Application No 15/00837/OUT

Location : Part Land on the North East  
Side of Gavray Drive  
Bicester

Proposal: OUTLINE - Residential development of up to 180 dwellings to include affordable housing, public open space, localised land remodelling, compensatory flood storage and structural planting.

### TOWN AND COUNTRY PLANNING ACT 1990 - LOCAL COUNCIL OBSERVATIONS

Figure 10: Indicative Movement Framework

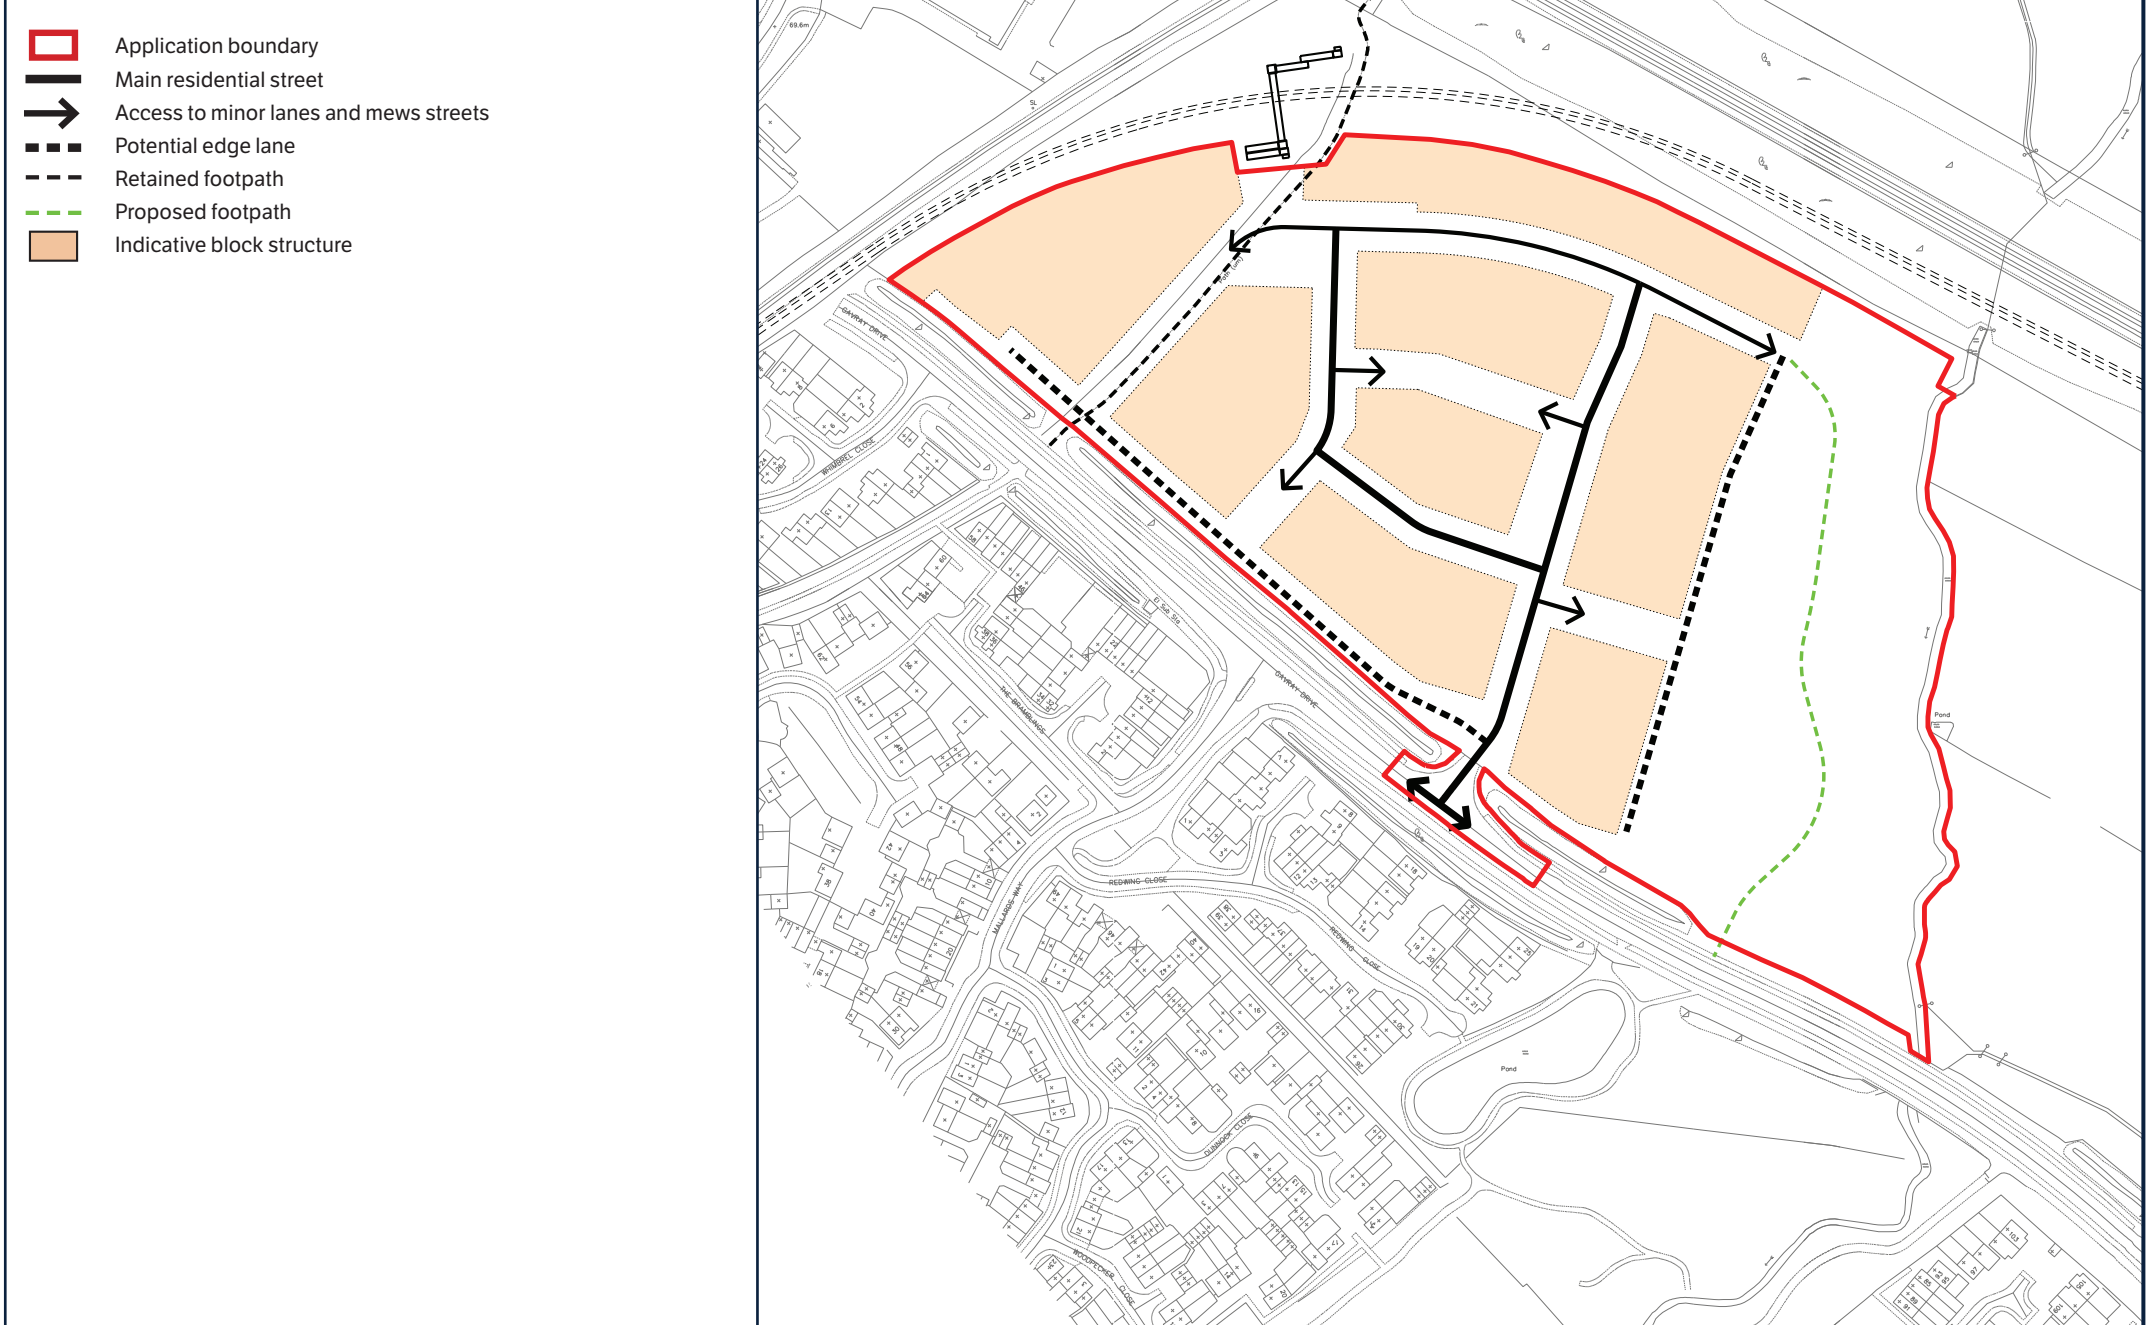
The LVIA is a comprehensive report and I mostly agree with its conclusions. However, in respect of photo-view EDP7 where the development will be clearly seen by visual receptors on the PROW and cycle way to Gavray Drive (there is no hedgerow in the way) , and I disagree with EDP's assumption that the receptor sensitivity is medium (Landscape and Visual – Constructional and Operational Effects) because of the existing urban influence. This should be judged as **high** visual sensitivity for receptors with a magnitude of change of **high** resulting in a significance of effect of **Major/Moderate (adverse)**, as considered from DLA/PDD's visualisation Fig 7 pp. 23 of the Design and Access Statement, April 23, against photo-view EDP 7. In order to effectively mitigate this potentially detrimental effect the landscape proposals must not only screen the built form but enhance the POS corridor/ flood Zone, as suggested in the illustrative masterplan, subject to EA approvals.

The public footpath is to be integrated into the scheme as proposed by the illustrative masterplan.

The northern site boundary would benefit from the woodland buffer planting as indicated on the illustrative masterplan, this will be have many environmental benefits especially in landscape mitigation terms: the screening of the railway corridor and visual receptors of the railway, and the screening of the northern edge of the development from the aspect of the over bridge/PROW

There is no provision for LAPs within the housing areas. There should be at least 4 un-equipped LAPs within 100 metres of the farthest extremity of the housing to allow for children, parents and carers to walk to the play area on 'safe' footways without the need to get in a car, and so more sustainable. A combined equipped LEAP and LAP is required in the area of POS that does not flood. The illustrative masterplan shows the play area overlays flood compensation which is unacceptable given future flooding problems and deprivation of play opportunities. A LAP should be located close to the PRow.
